From: Roger Spencer <Roger.Spencer@arun.gov.uk>
Sent: 31 October 2019 17:26
To: Planning.Responses <Planning.Responses@arun.gov.uk>
Subject: RE: Planning Consultation on: LU/252/19/PL

Further Engineers' Comments

NOTIFICATION FROM ARUN DISTRICT COUNCIL
Town & Country Planning Act 1990 (as amended)
Town and Country Planning (Development Management Procedure) (England) Order 2015
Planning Permission
APPLICATION NO: LU/252/19/PL

Site Address: Yeomans Honda Horsham Road Littlehampton BN17 6DN

Drawing
PROPOSED SITE PLAN

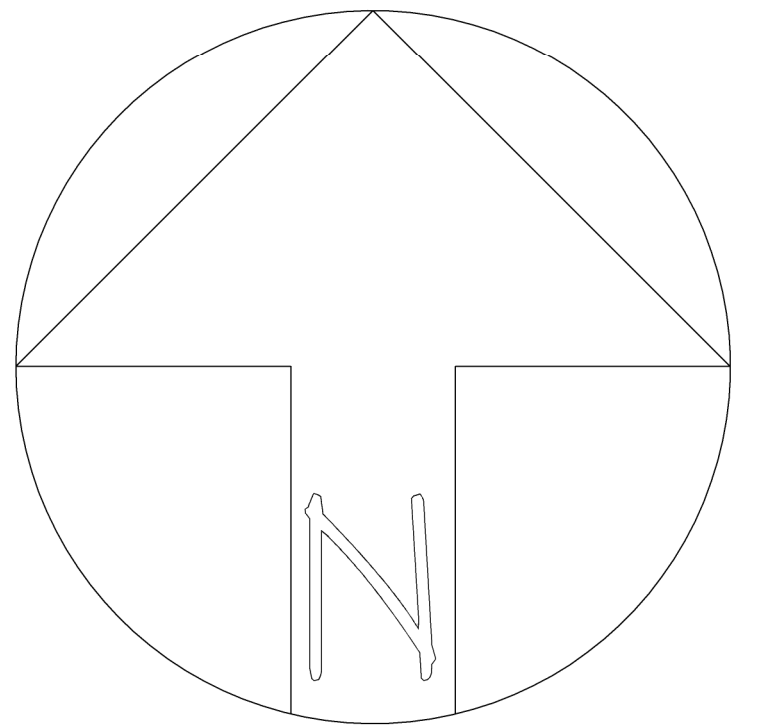
It would seem that the area was suitably remediated as part of the Permitted change from petrol filling to forecourt some years ago (the Applicant informs me that the fuel tanks were slurry/grout filled). The tanks are still in place and would be in the area now being changed in terms of levels and so it would be unwise to disturb and/or infiltrate to the ground in this area, both for the existence of the tanks and for any pollutants that may exist outside of the immediate tank area.

The flow to main sewer (mentioned in my previous message) would seem to have been a requirement of the previous conversion, where the car washing effluent was required to go to the sewer with a commercial licence from Southern Water. There is no change in impermeable area (and therefore volume) being discharged to the sewer.

Given that the area of the forecourt that is to be regraded was previously occupied by a petrol filling facility, I am surprised that the Application shows 'no' to all points regarding contamination. Perhaps it was fully remediated when the filling facility was removed (1992?)

I am also concerned that the application shows surface water going to 'main sewer'. There is no public surface water sewer in Horsham Road, thus the proposal is seemingly to discharge to the combined sewer, although this is not detailed.

It is right that the run-off (which may also include some of the roof area of the existing building) should not discharge to the highway – as it would if the channel drains were not in place - any connection to foul or combined sewers should be avoided and the normal hierarchy of surface water disposal should be followed if at all possible. There would seem to be sufficient area to provide infiltration although we are not provided with groundwater or permeability data to assess this.

The existing arrangement should be investigated; whilst it may be that the existing slot drains may discharge to the 'main sewer', we should be seeking betterment and endeavouring to have surface water flow removed from the combined sewer as part of this development.

Therefore, if it can be shown that all of the above is correct with the new channel drains being connected via the same arrangements as previously and Southern Water have no concern regarding the revised arrangement, I have no objection to the proposals. It would be worthwhile ensuring a management plan was in place to ensure that the channel drains were cleaned out on a sufficient frequency so as to avoid the risk of direct discharge to the highway.
